Arun District Conservation Area Advisory Panel
c/o Civic Centre

4th May 2021

Application No: AB/49/21/PL
Site Address: Old Bank House 1 High Street Arundel BN18 9AD
Description of works: Replacement of all windows with new timber double glazed sliding box sash windows and the proposed rendering of the South Elevation (front) and the West Elevation (side) with render painted white. This application may affect the setting of a Listed Building and affects the character and appearance of the Arundel Conservation area.

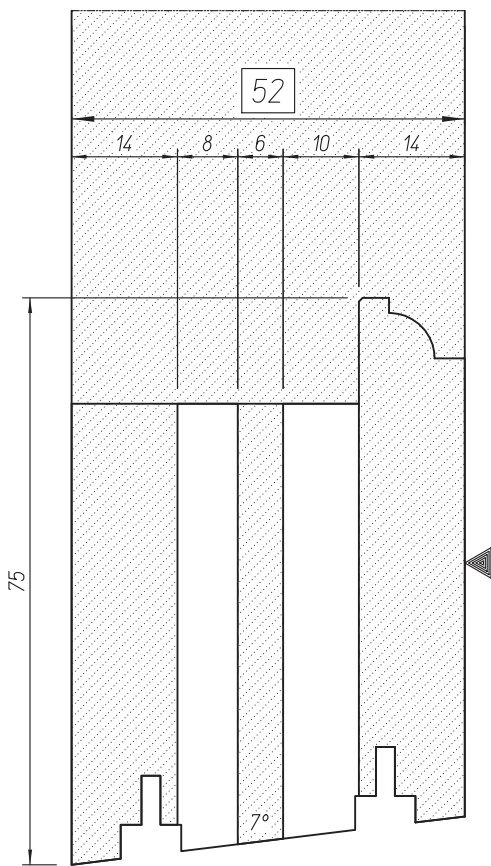
The replacement of this important fenestration with timber double glazed windows with their thicker glazing, dead flat appearance to the glass and thermal spacers will materially detract from the historical and architectural significance of this listed building. It is difficult to ascertain from the submitted plans how any glazing bars, if any, will be treated. It is either intended to use false 'stick on' bars or to use properly formed bars but these would need to be thicker than the originals in order to take the extra weight of the double glazing (this would also likely be the case even with slimline glazing units). Either detail is simply not appropriate since the existing traditionally constructed slender glazing bars are so important to the character and appearance of the historic building.

Without detailed proposed full elevational plans of the various window sizes contained in the building it is difficult from the plans submitted to ascertain final appearances.
